**Town of Addison
Summary of Engineering Revision Comments**

Development: Galaxy FBO

Town Project #:19-09D

Town of Addison Engineering Review Conditional Civil Approval

SHEET NUMBER
C08.02

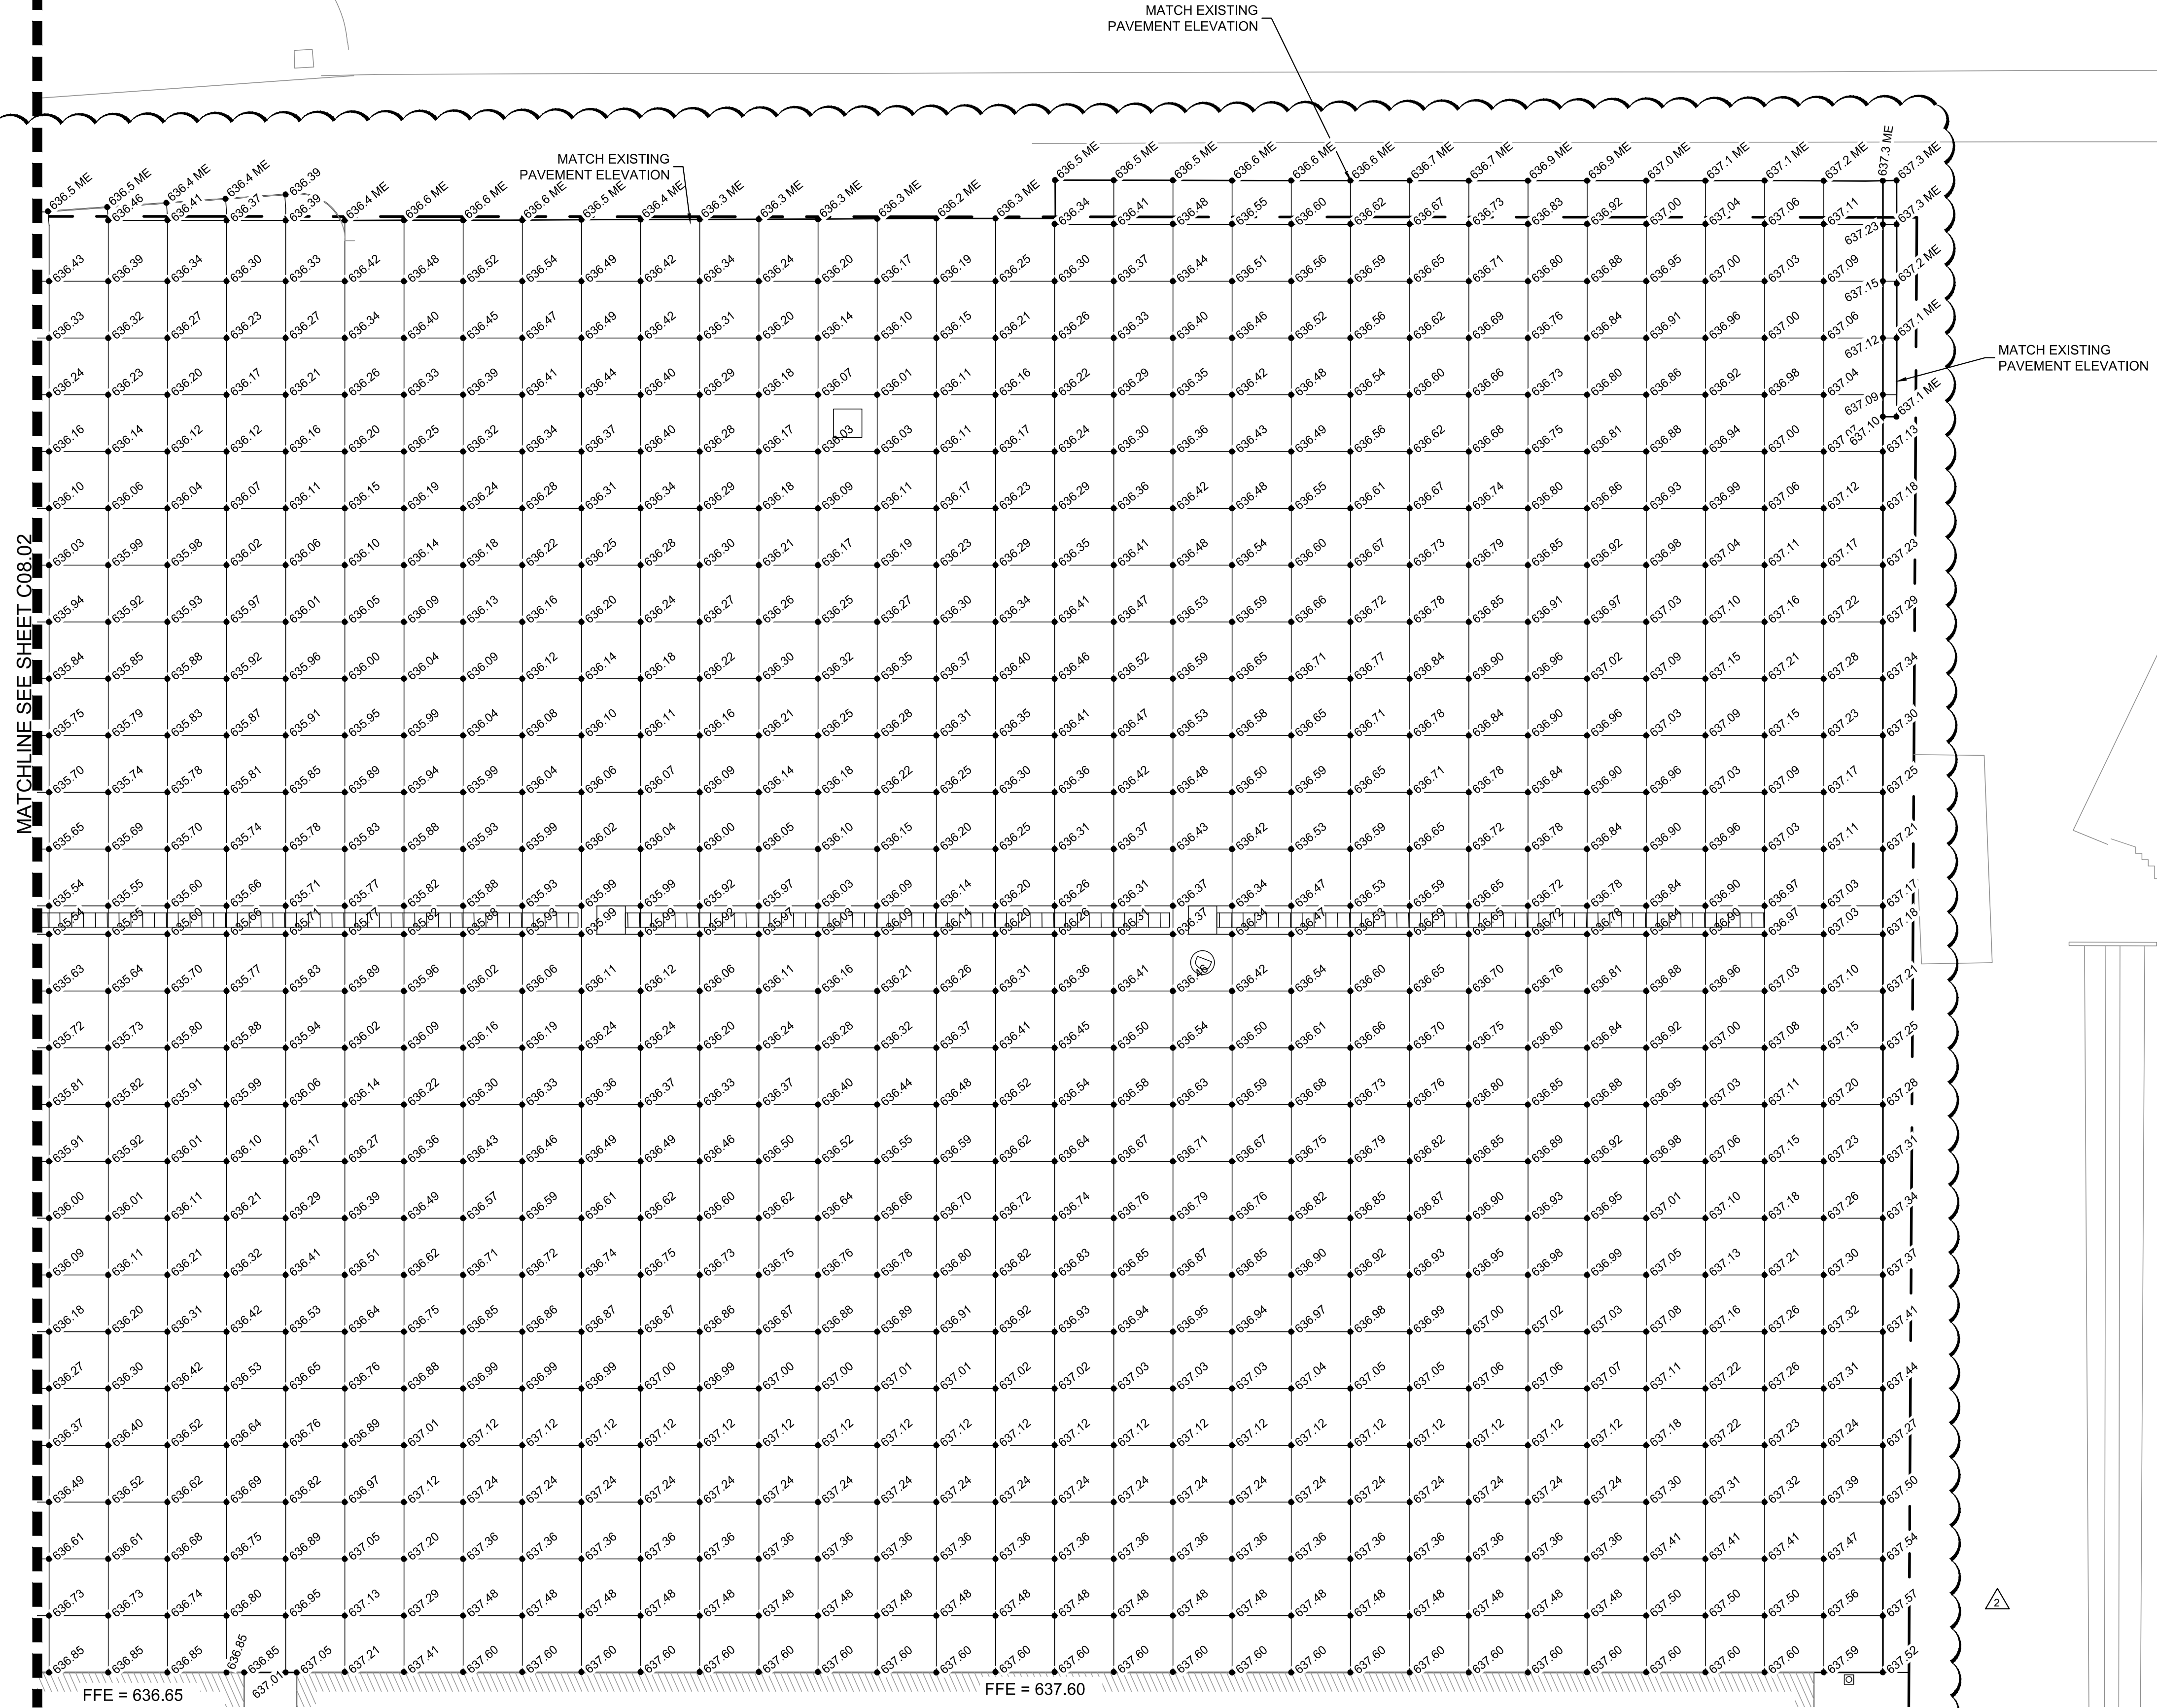
ASI-C006	10/30/2020	C08.01	Updated grading per field conditions verified by a construction progress topographic survey.	
ASI-C006	10/30/2020	C08.02	Updated grading per field conditions verified by a construction progress topographic survey.	
ASI-C006	10/30/2020	C08.03	Updated grading per field conditions verified by a construction progress topographic survey.	
ASI-C006	10/30/2020	C09.01	Updated grading per field conditions verified by a construction progress topographic survey.	
ASI-C006	10/30/2020	C09.02	Updated grading per field conditions verified by a construction progress topographic survey.	
ASI-C006	10/30/2020	C09.03	Updated grading per field conditions verified by a construction progress topographic survey.	
ASI-C006	10/30/2020	C10.02	Updated grading per field conditions verified by a construction progress topographic survey.	
ASI-C006	10/30/2020	C10.03	Updated grading per field conditions verified by a construction progress topographic survey.
